From: Faulkner, Stephen <stephen.faulkner@norfolk.gov.uk>
Sent: 01 February 2019 13:40
To: Norfolk Vanguard
Cc: [REDACTED]
Subject: RE: Local Impact Submission - Norfolk County Council
Attachments: Appendix 1 - Detailed Comments_V2_LLFA.PDF

Further to Norfolk County Council's submission of its Local Impact Report (LIR) below, I have attached an amended Appendix 1 of the LIR, which makes a minor factual amendment to paragraph 1.15 (proposed condition/requirement – surface water drainage).

Response to Norfolk Vanguard DCO Application - Detailed Environmental, Highway and Flood Risk Comments

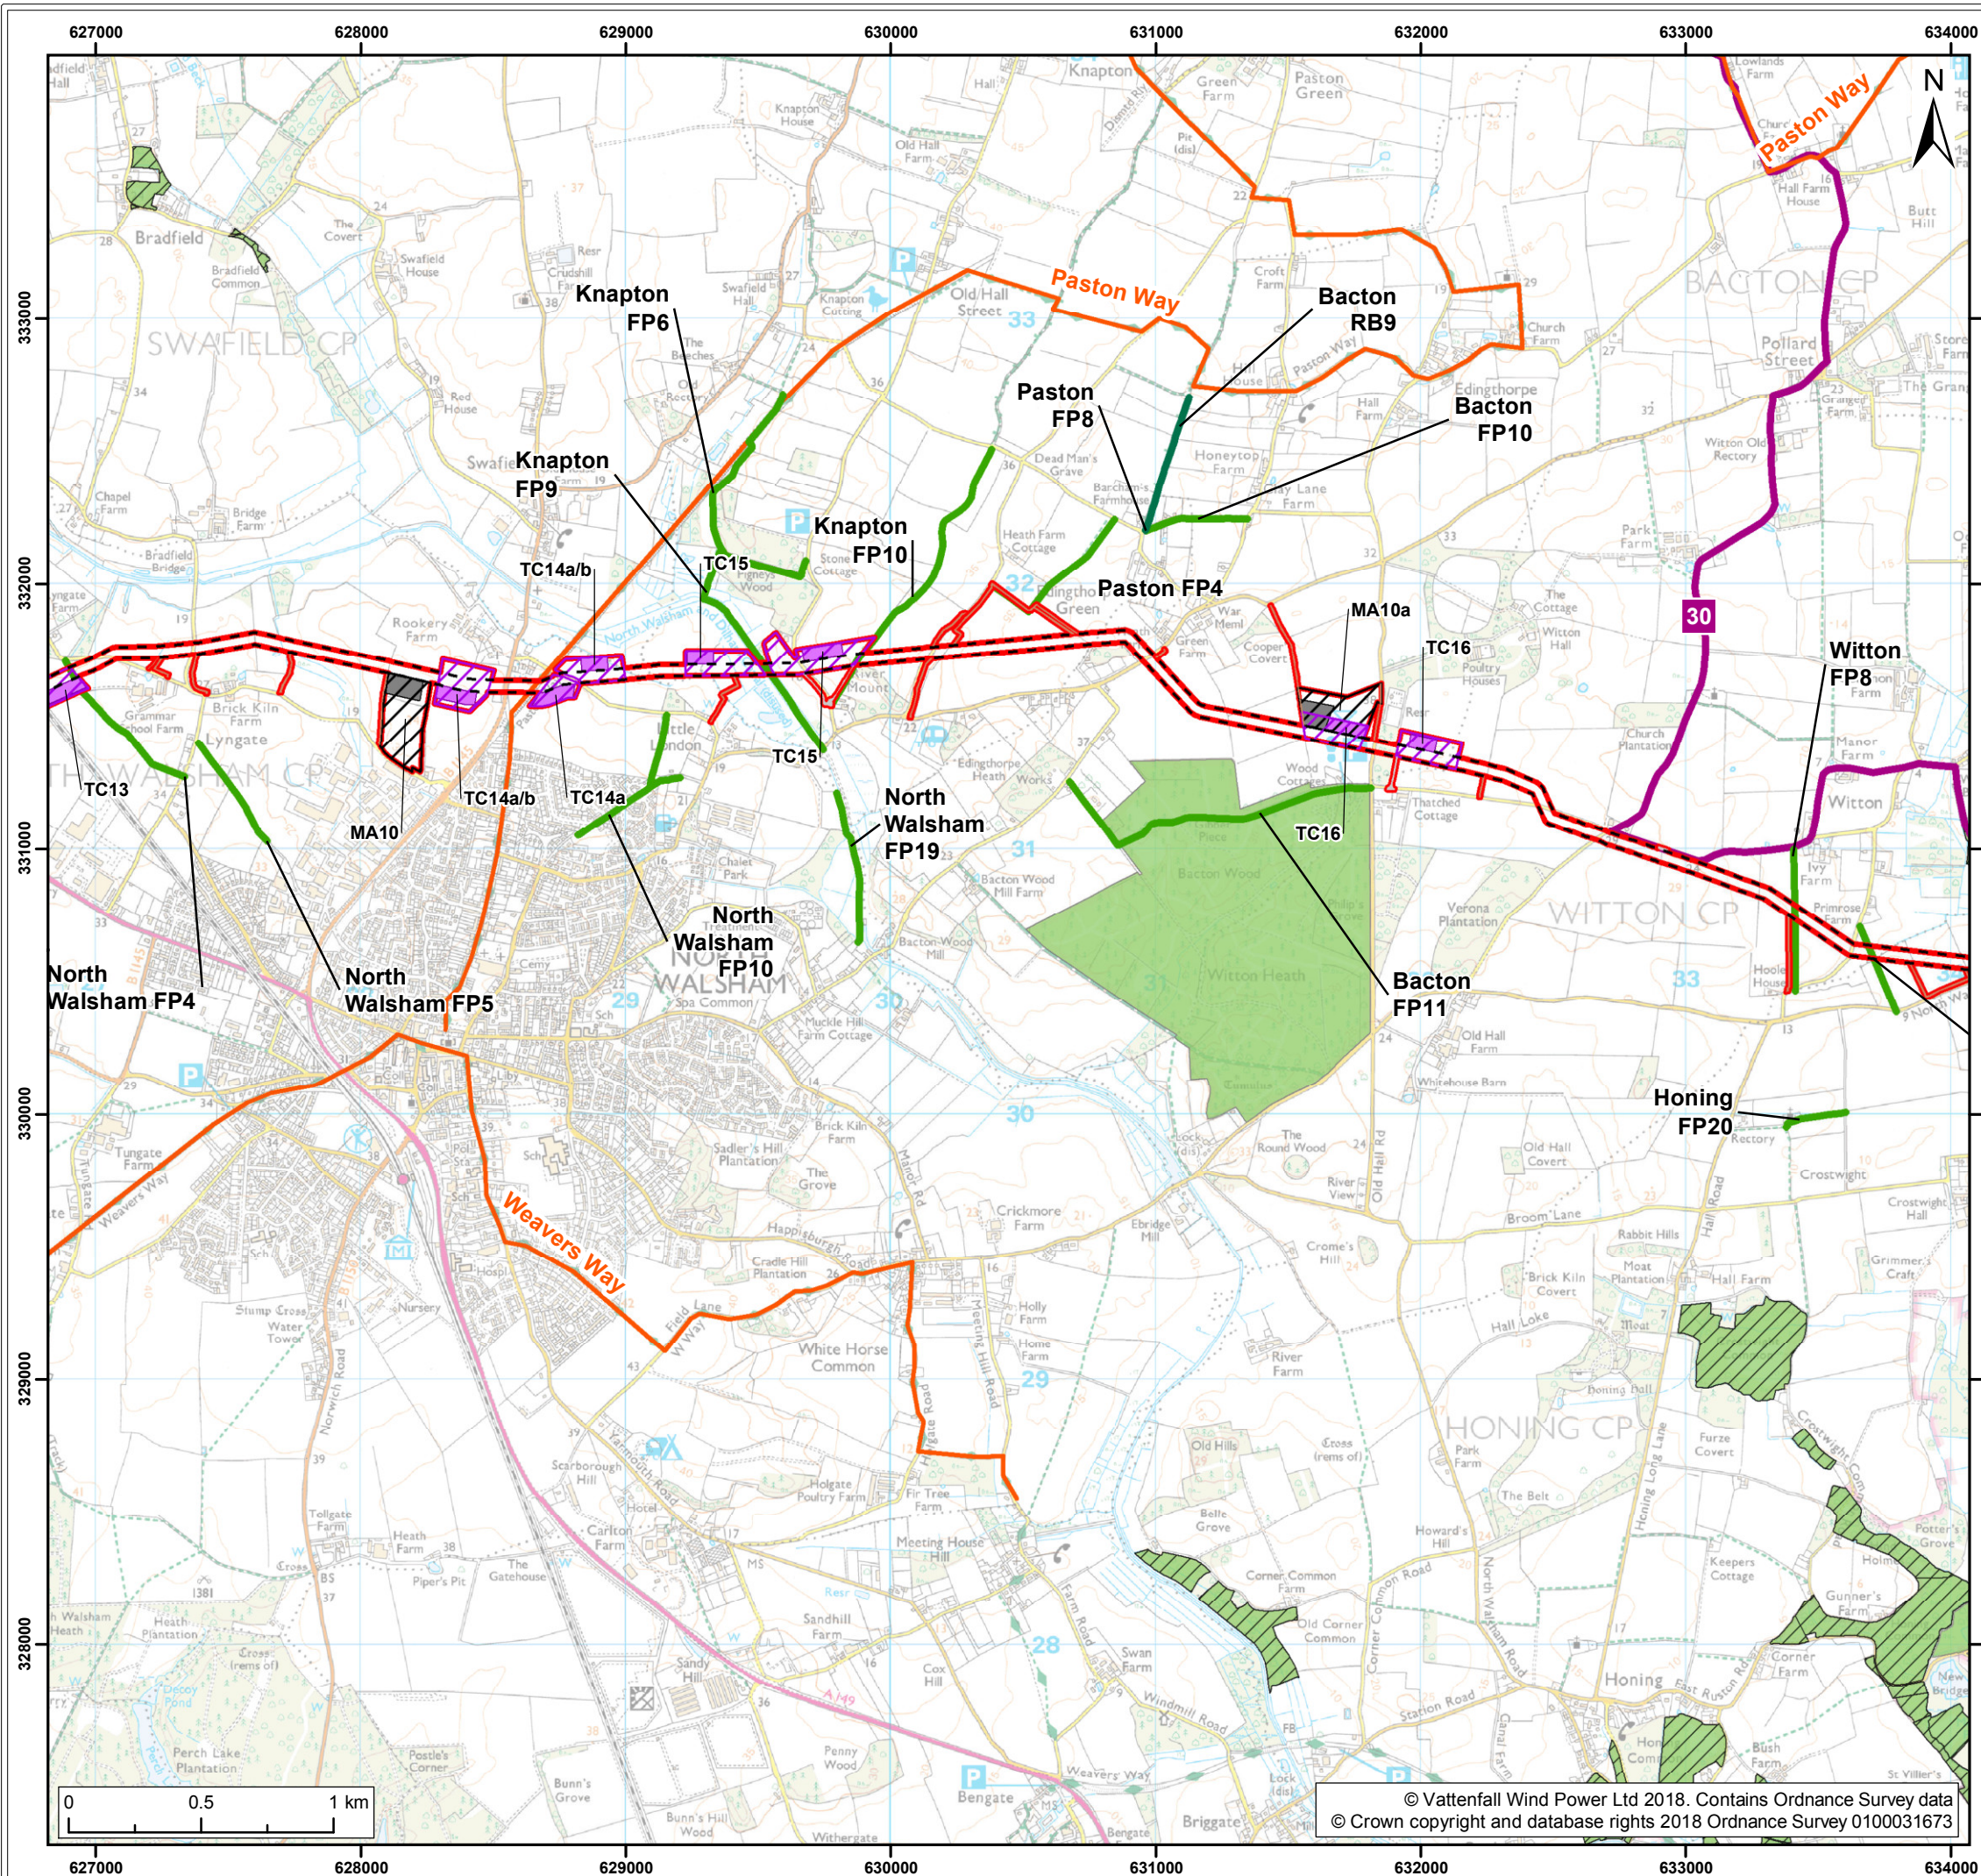
- 1.1. It is noted that the onshore cable route intersects with Public Rights of Way (PRoW), including National and County Trails, at 45 locations. Mitigation for impacts on users of the PRoW network is in the form of embedded ('designed-in') mitigation and method statements.

- 1.2. Norfolk County Council welcomes the use of HDD underneath some of the particularly heavily-used recreational routes (long-distance trails), particularly at landfall where the cables will intersect with the England Coast Path. HDD is also proposed for cable-laying across two further Trails managed by Norfolk Trails, namely Marriott's Way (twice) and Paston Way (both these sites are also designated County Wildlife Sites at the crossing points). This approach should result in negligible disruption to users of these Trails. It is noted that HDD is not proposed at the crossings of two further Norfolk Trails, the Wensum Way and Weaver's Way, nor the majority of the crossing points of the general PRoW network.

- 1.3. Mitigation for impacts on the majority of the PRoW and Trails network will be addressed by two documents: A *Public Right of Way Strategy*, and a *Code of Construction Practice* (CoCP), draft versions of which have been submitted with the DCO application. The Council believes these documents should result in appropriate measures to manage impacts in relation to cable-laying. In relation to the discharge of the DCO requirement for the CoCP, the documents refer to liaison with the "relevant local planning authority" (e.g. CoCP, section 4; paragraph 71; p 16). However, when it comes to matters relating to PRoW and Trails, it is felt that the County Council as the Highways Authority should be the relevant local authority to agree the management of PRoW.

- 1.4. The County Council welcomes the intention of the applicant to liaise with the PRoW Officers and Trail Officers over short-term temporary diversions of PRoW or other potential impacts. This will be important in reducing the burden on NCC in managing matters relating to the PRoW network with regards to the cable-laying works. The County Council also welcomes the approach for providing advanced warning of works that would affect PRoW. Where Norfolk Trails would be affected, it would additionally be helpful if information could be provided for inclusion on the Norfolk Trails website.
